11/10/2021

SF2018/318466 | WST18/00146/07

**SSD-10419: consolidated mining lease (CML) 6, mining purposes lease (MPL) 854 and mining lease (ML) 1483 and ML 1805; Kidman Way (MR410), Cobar
New Cobar Complex Project**

Figure 5: Project Intersections

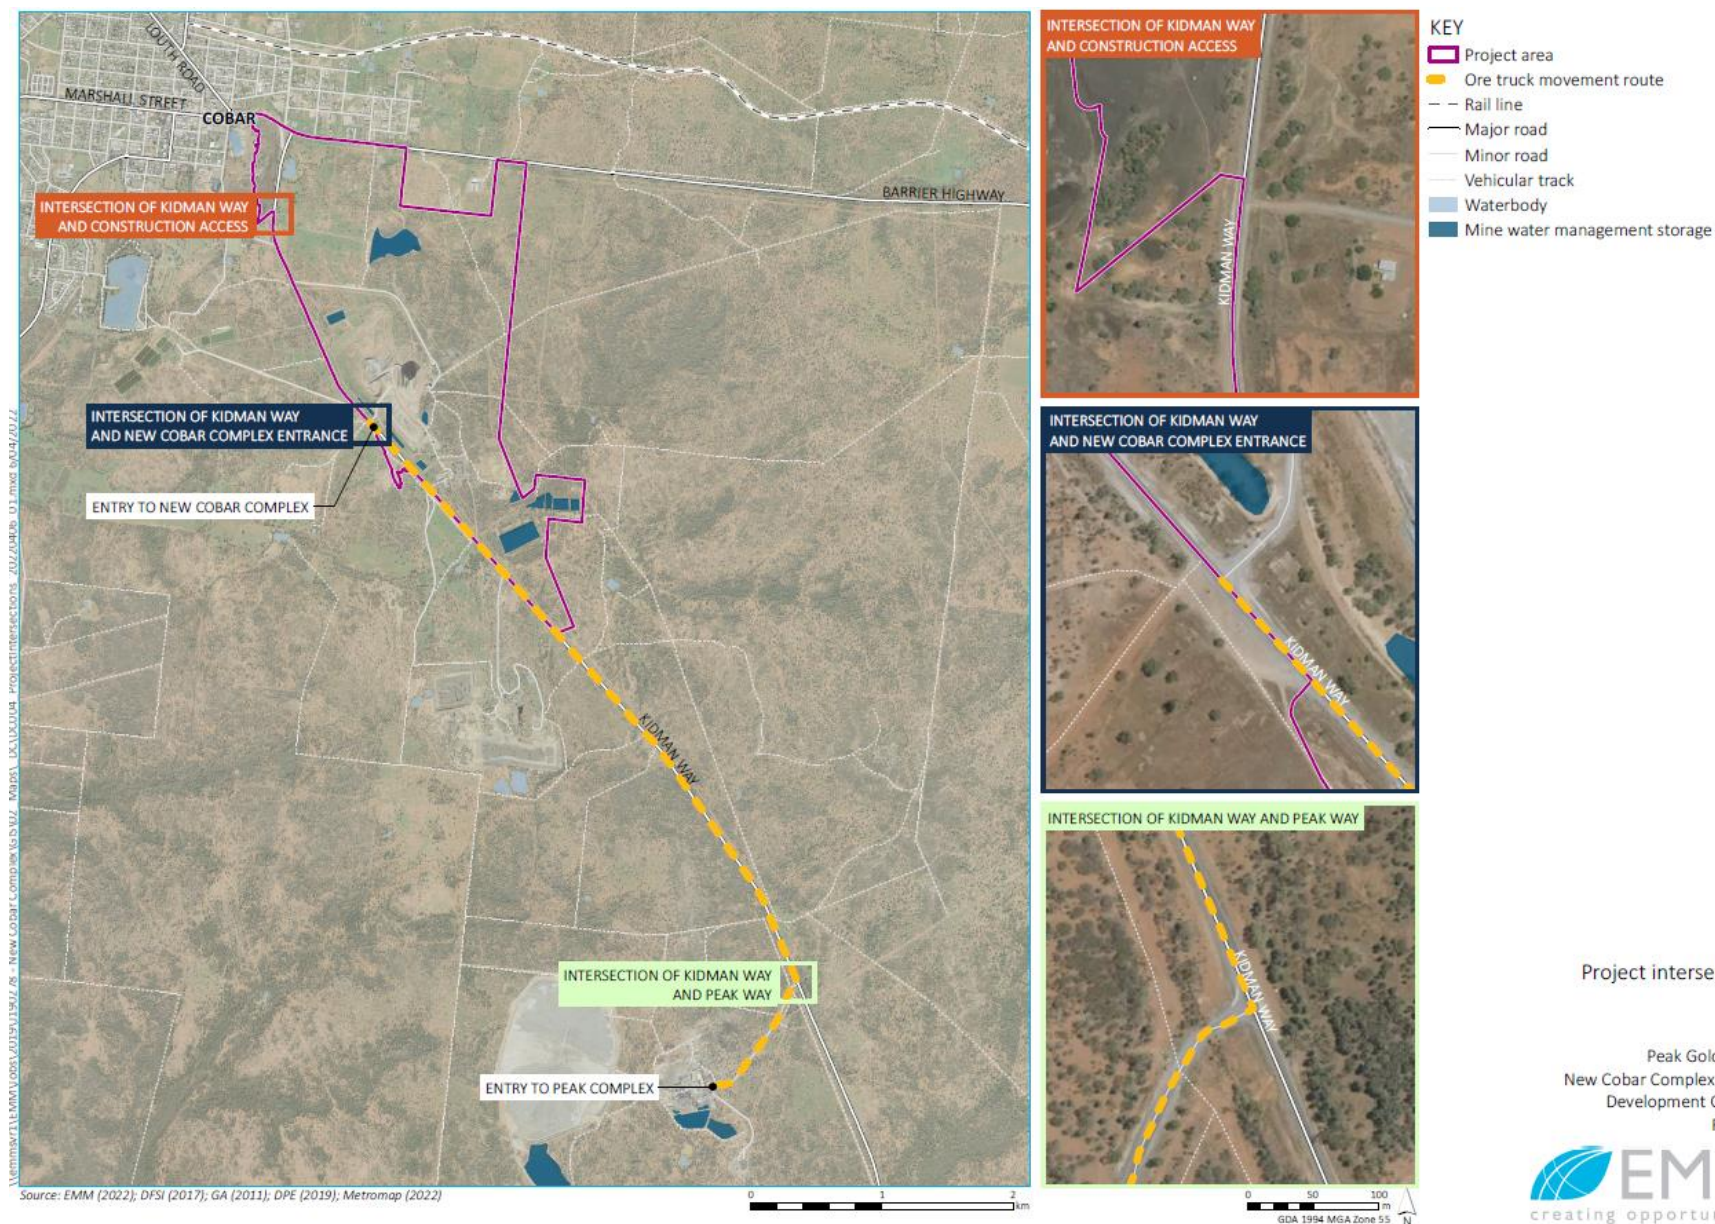
- Prior to the commencement of construction works, the intersection of the Kidman Way/Construction Access must be upgraded as follows:
 - A Rural Basic Left-Turn (BAL) Treatment (see Figure 8.2 of Part4A of AGTRD) is to be provided to accommodate 19m long design vehicle.

- A Rural Basic Right-Turn (BAR) Treatment (see Figure A6 of Part4 of AGTRD) is to be provided to accommodate 19m long turning design vehicle and the highway design vehicle length of 36.5m.

- The property access leg of the intersection is to be sealed to a distance of 20m from the hold line of the intersection.
 - Safe Intersection Sight Distance (SISD) requirements as per Austroads Guide to Road Design Part 4A and relevant TfNSW Supplements to Austroads is to be provided and maintained in both directions at the intersection. For a 90 km/h operating speed a minimum SISD of 214 metres should be provided.

- Prior to commencement of the development, the intersection of the Kidman Way/Peak Way Access must be upgraded as follows:

- A Rural Basic Left-Turn (BAL) Treatment (see Figure 8.2 of Part4A of AGTRD) is to be provided to accommodate 35.4m long design vehicle.
- Upgrade to accommodate the turning movements of a 35.4m B-Triple vehicle.

Figure 4.1 Concept New Cobar Complex heavy vehicle access intersection upgrade

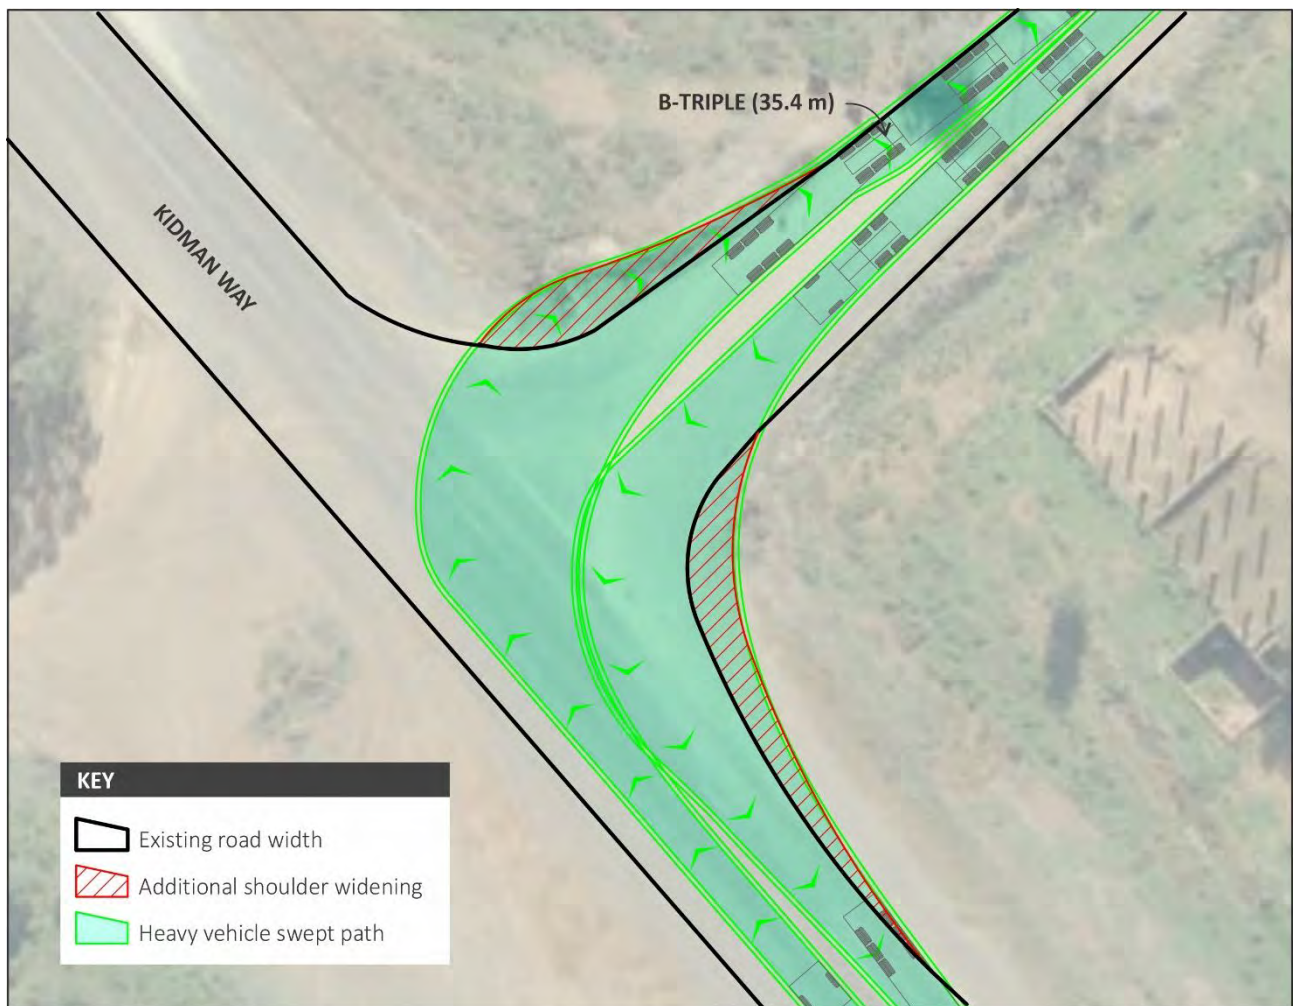
- Prior to commencement of the development, the intersection of the Kidman Way/New Cobar Complex Access must be upgraded to accommodate the turning movements of a 35.4m B-Triple vehicle as generally shown on EMM Drawing J190278 EMM-001 Revision 1 dated 22/4/2020.
